***Planning Department
Transportation Development Services***

November 5, 2015

**Re: The Carlisle
3600 Central SE
Traffic Circulation Layout**
Engineer's/Architect's Stamp dated 11-1-15 (K17-D069)

Based upon the information provided in your submittal received 11-4-15, the above referenced plan cannot be approved for Building Permit until the following comments are addressed:

[illegible]

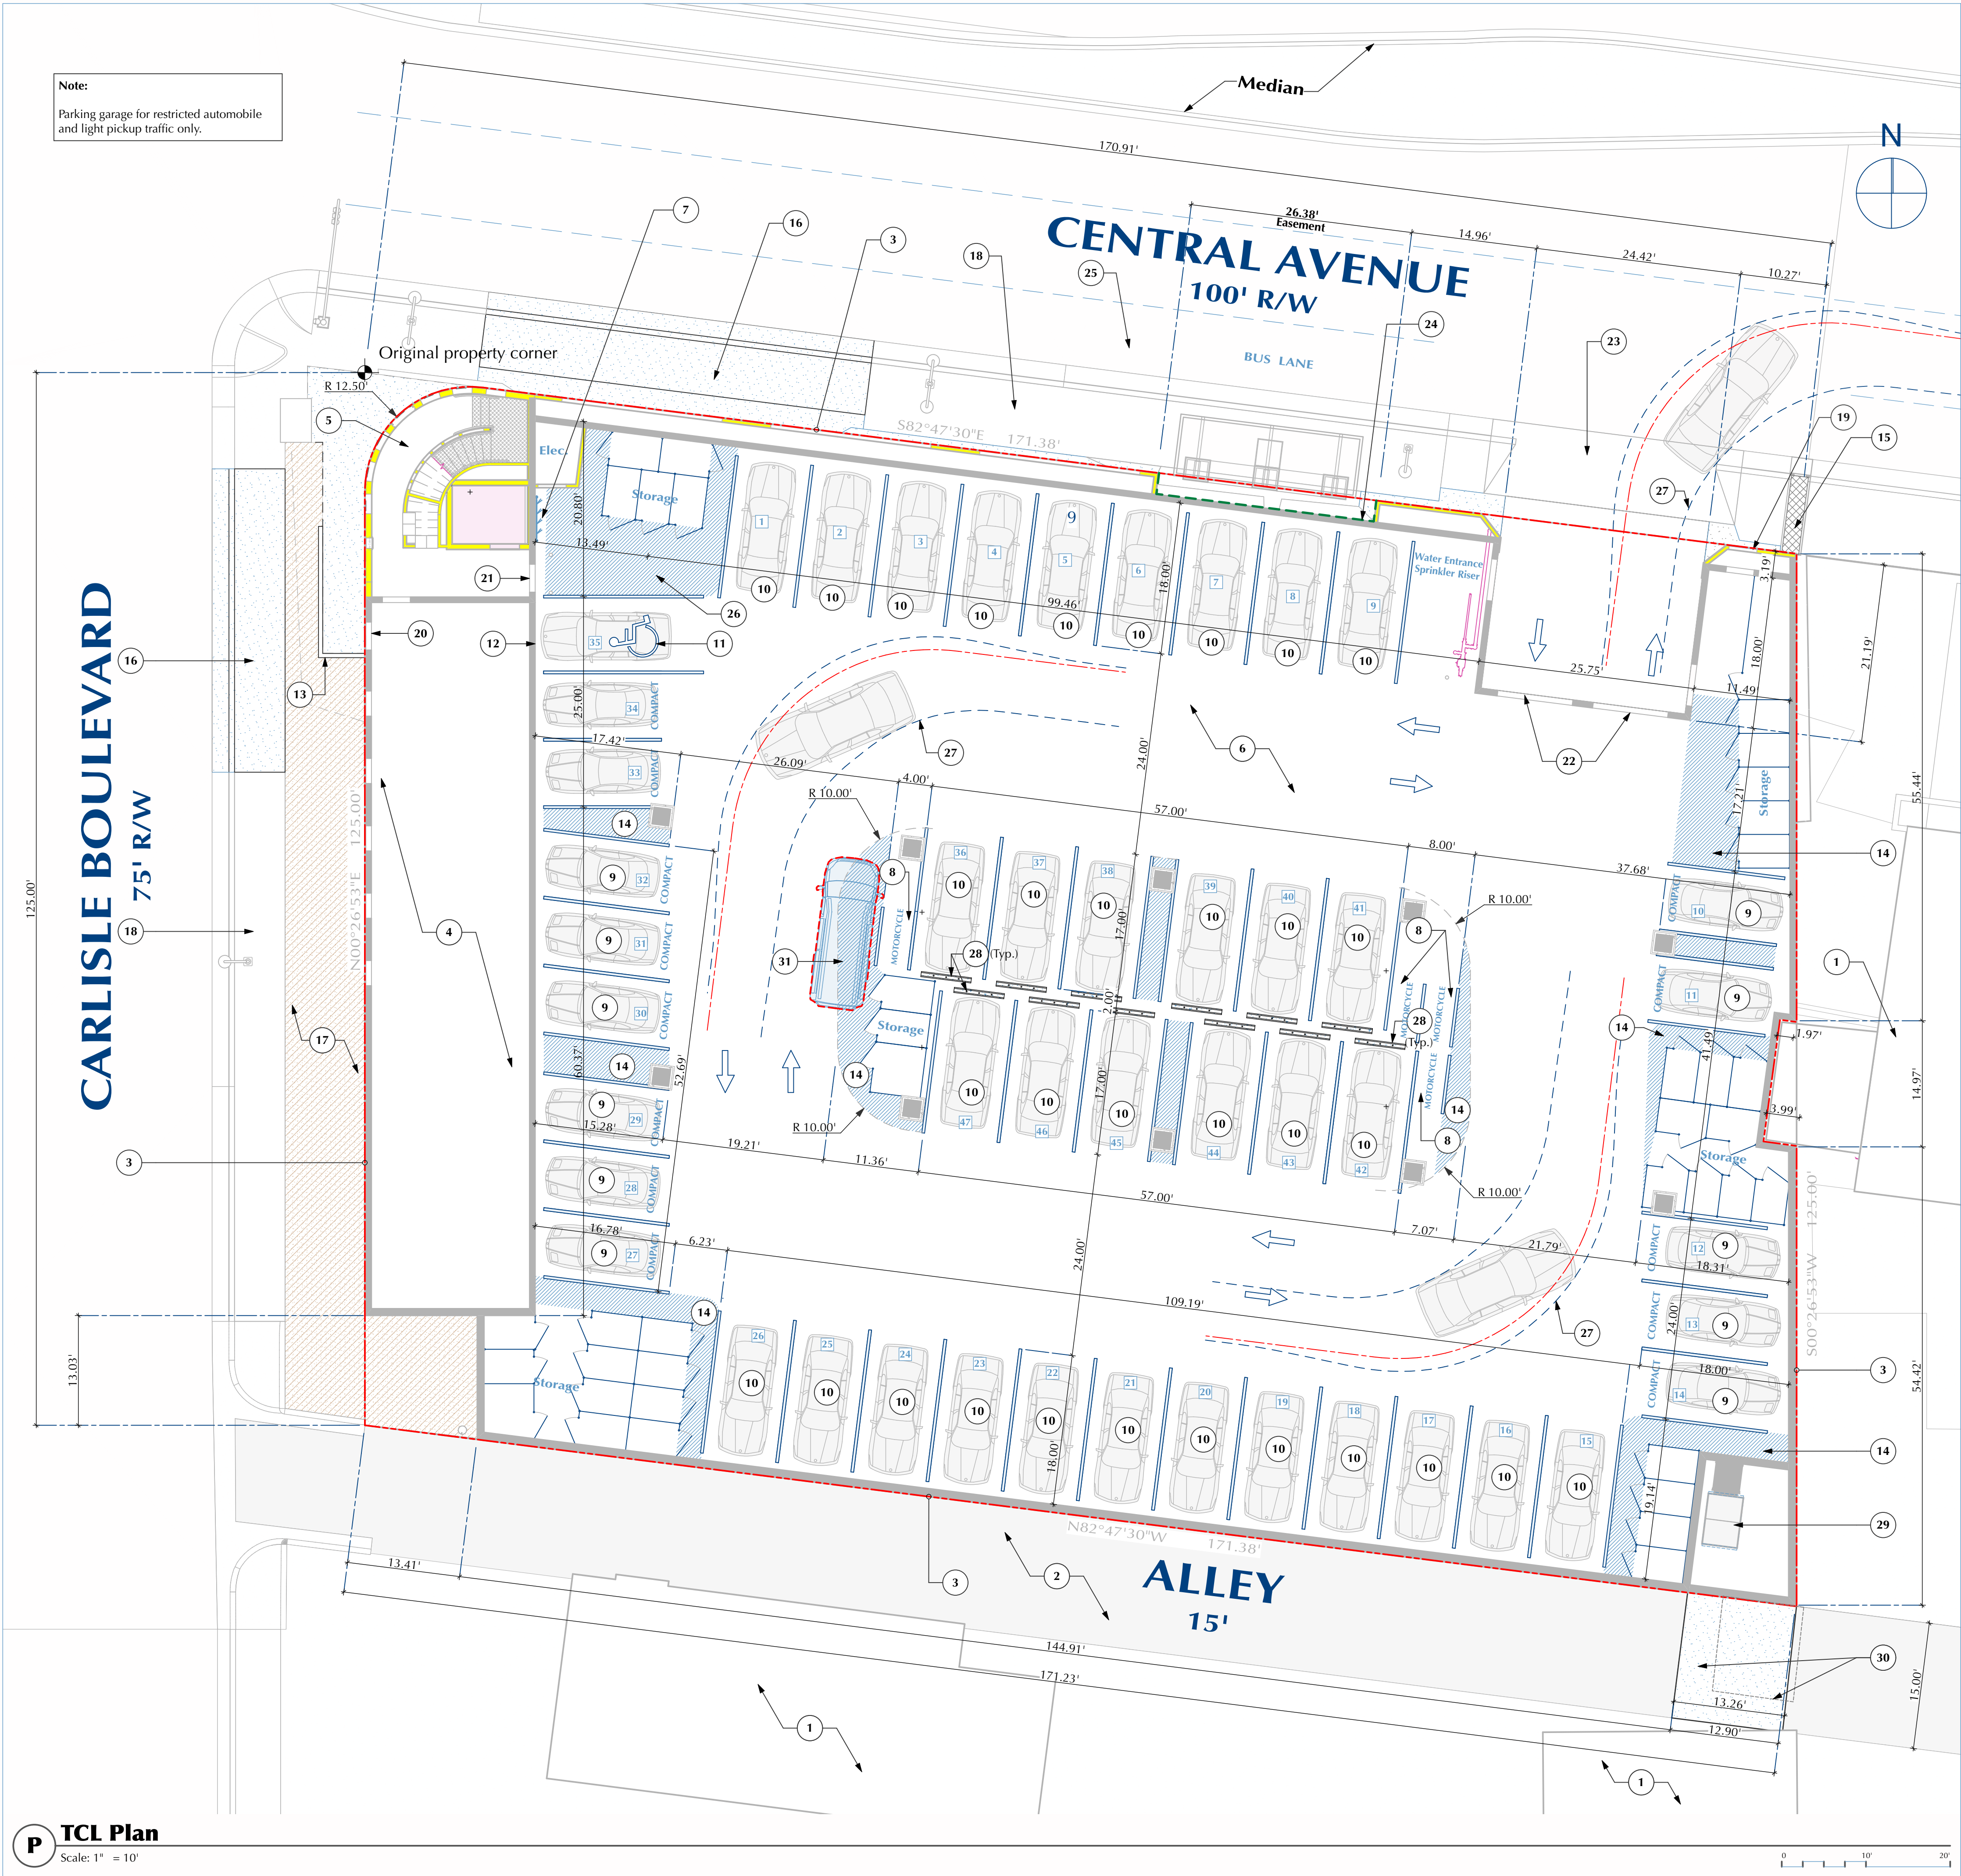
1. Please provide a sight distance exhibit signed and stamped by N.M. professional engineer.
2. Please add the following note to the clear sight triangle: "Landscaping and signage will not interfere with clear sight requirements. Therefore, signs, walls, trees, and shrubbery between 3 and 8 feet tall (as measured from the gutter pan) will not be acceptable in this area."

3. Please show a vicinity map showing the location of the development in relation to streets and well known landmarks.
4. Identify all existing access easements and rights of way with dimensions, including alley on the south side of proposed building.

5. Identify the right of way width, medians, curb cuts, and street widths on Carlisle Blvd., Central Ave. and public alley on the south side of proposed building.

6. The ADA accessible parking sign must have the required language per 66-7-352.4C NMSA 1978 **"Violators Are Subject to a Fine and/or Towing."** Please show a detail of ADA signage.

7. The ADA access aisle shall have the words **"NO PARKING"** in capital letters, each of which shall be at least one foot high and at least two inches wide, placed at the rear of the parking space so as to be close to where an adjacent vehicle's rear tire would be placed. (66-1-4.1.B NMSA 1978) Please clearly label the width of the ADA access aisle.

8. Per the DPM, a 6 ft. wide ADA accessible pedestrian pathway is required from the public sidewalk to the building entrances. Please clearly show this pathway and provide details, including slope details of pedestrian pathway to the building entrance.

9. Per the DPM, a 6 ft. wide ADA accessible pedestrian pathway is required from the HC parking stall access aisles to the building entrances. Please include details of ADA access to lobby and elevator.

10. Provide a min 6" or max 8" high concrete barrier curb or other acceptable barrier between landscaping and parking areas and/or drive aisles. Please detail barrier curb.

11. Design delivery vehicle route needs to be shown.
12. Service vehicle and/or refuse vehicle maneuvering must be contained on-site; provide a copy of refuse approval. Please clearly show location of refuse container.

13. Unused curb cuts must be replaced with sidewalk and curb & gutter. A build note must be provided referring to the appropriate City Standard drawing.
